DEPARTMENT OF PARKS AND COMMUNITY SERVICES

December 5, 2024

Subject: Esteban Rodriguez Preliminary Plan, Preliminary Comments (SP-24-005)

SHEET NO. PLP1.0
1 of 8 SHEETS

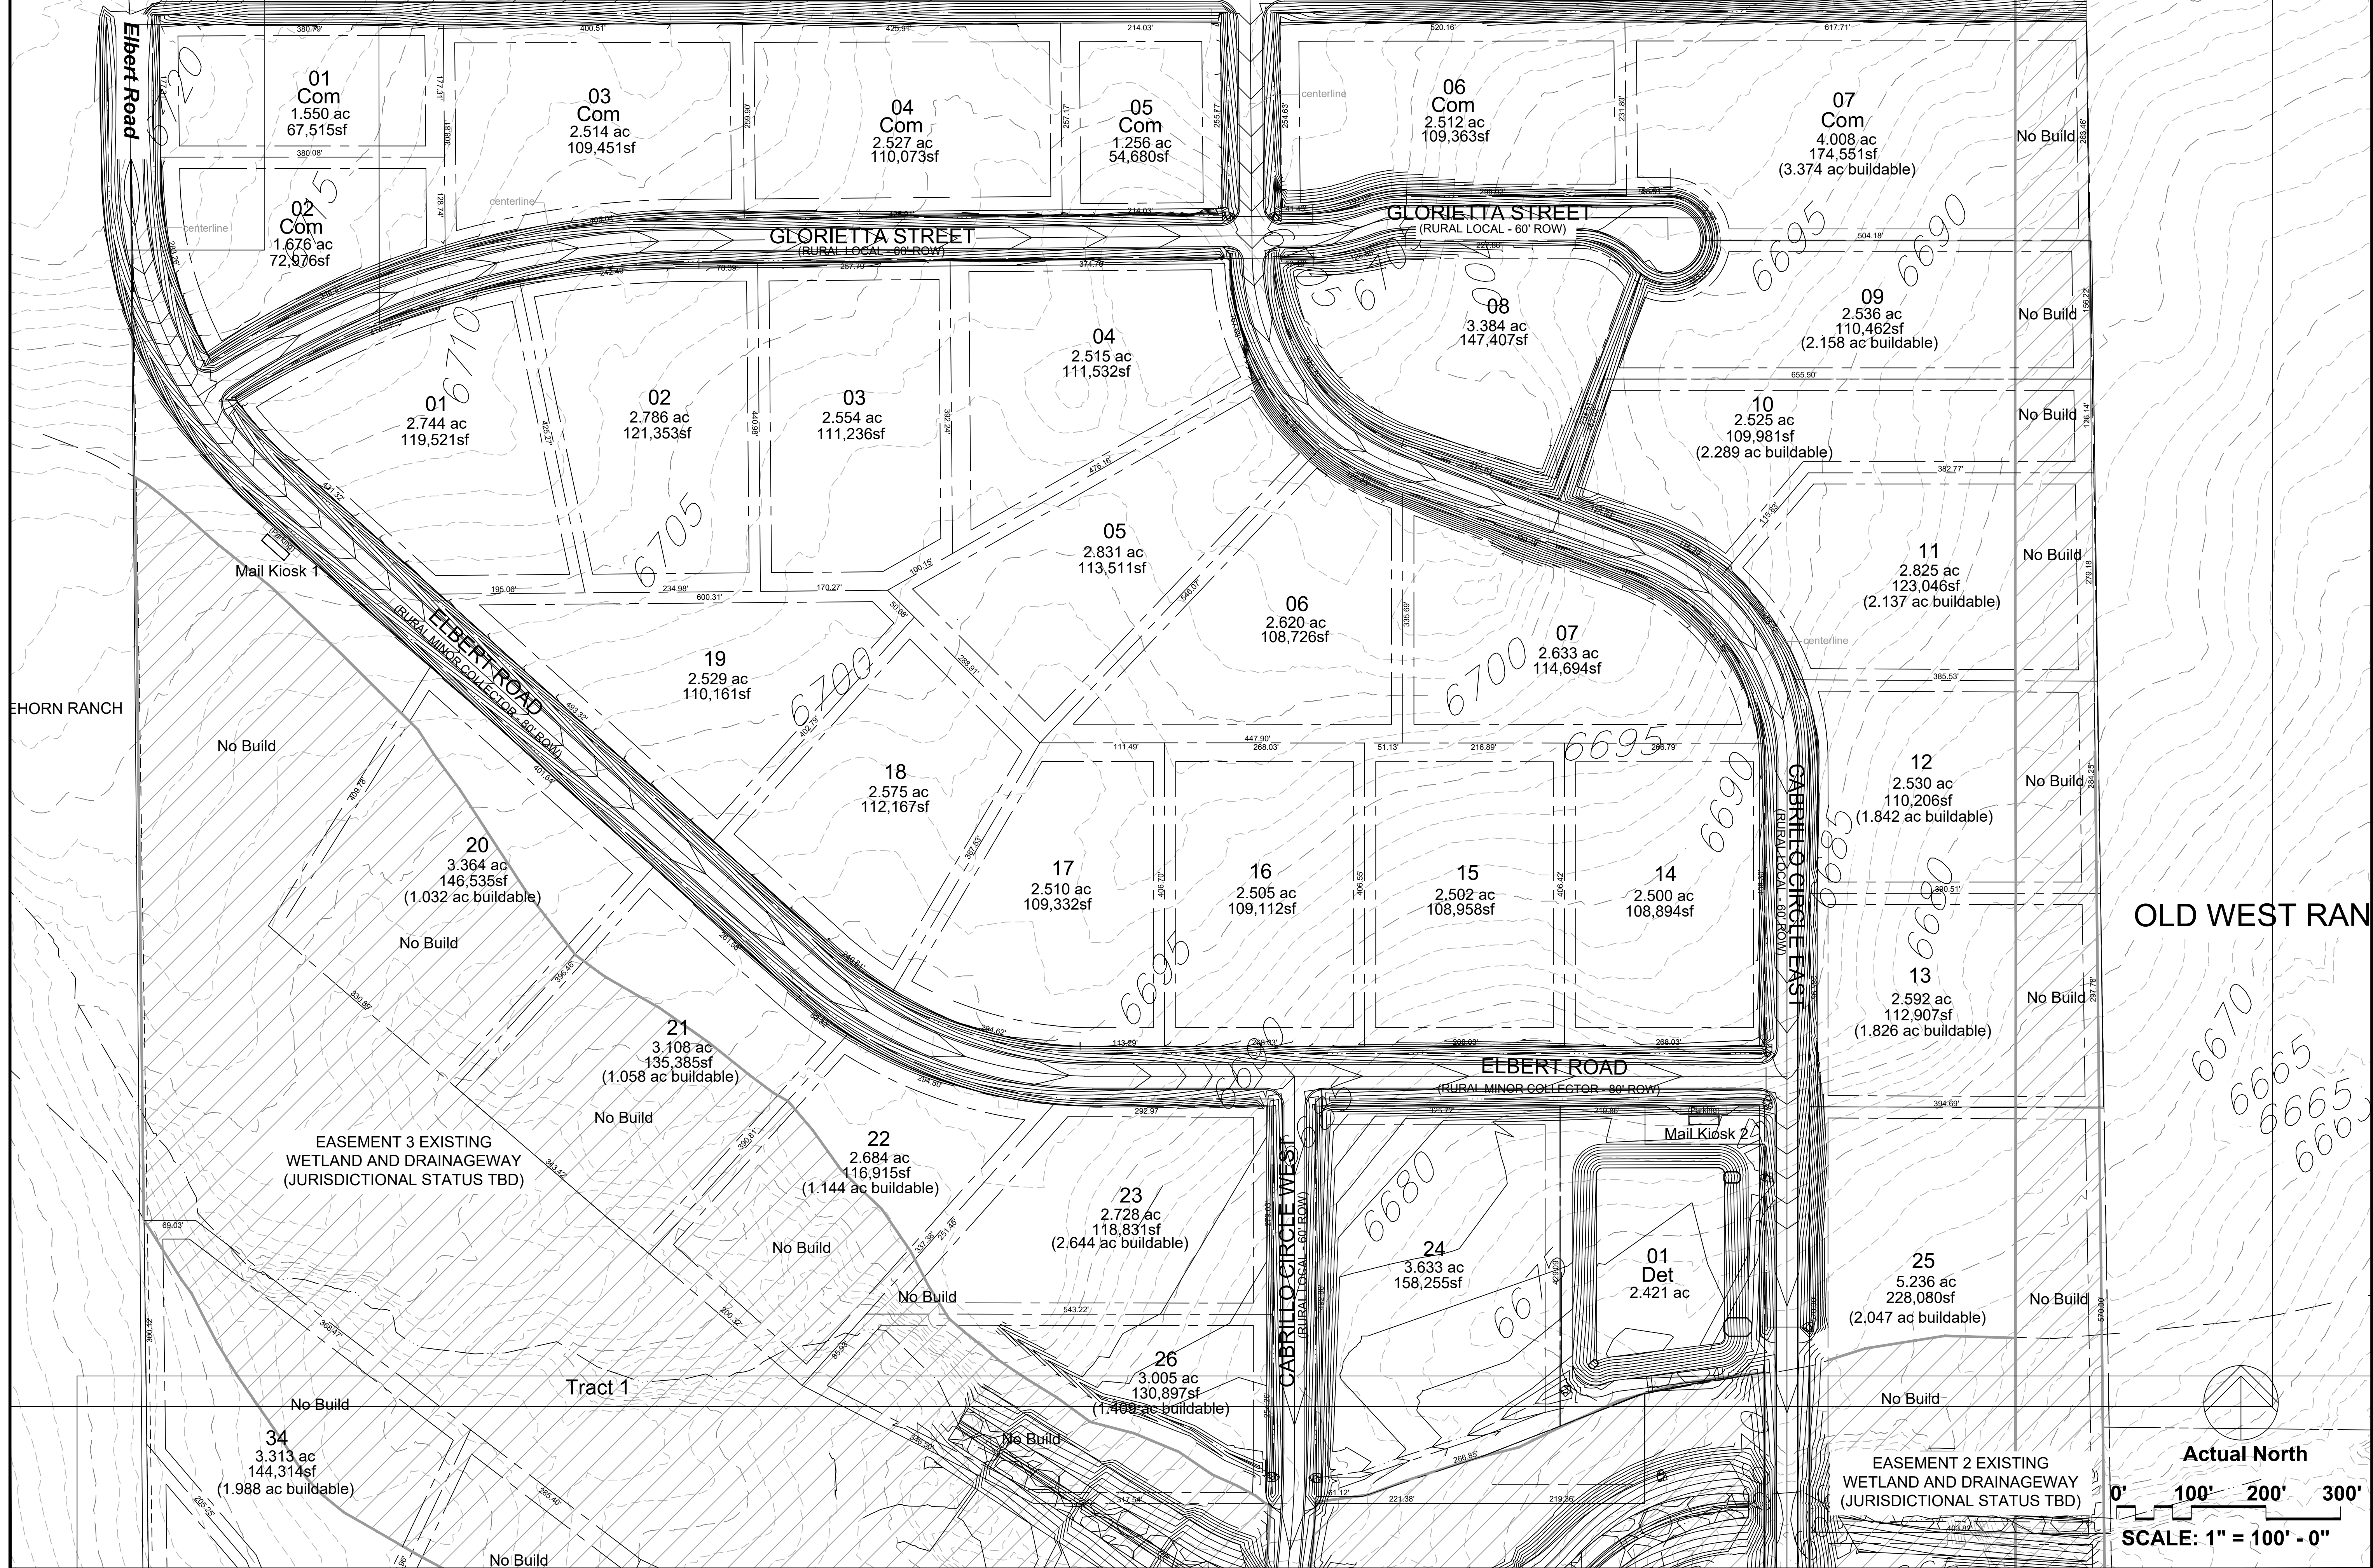
Due to nonconformity of the Preliminary Plan in relation to the approved Sketch Plan, staff asks that the applicant address the removal of the previously approved 8.44-acre community park, add the park to future submittals of the Preliminary Plan, clearly display and notate the internal trail corridors and public trail easements as were originally shown and noted on the Sketch Plan, and resubmit the Preliminary Plan for further review.

The Park Advisory Board recommends that the Planning Commission and the Board of County Commissioners include the following condition when considering and/or approving the Esteban Rodriguez Preliminary Plan: (1) address the removal of the 8.44-acre community park, and add the park to forthcoming submittals of the Preliminary Plan; (2) display and notate the internal trail corridors and public trail easements; (3) fees in lieu of land dedication for regional park purposes in the approximate amount of \$72,720 will be recalculated prior to and required at time of the recording of the forthcoming Final Plat(s).
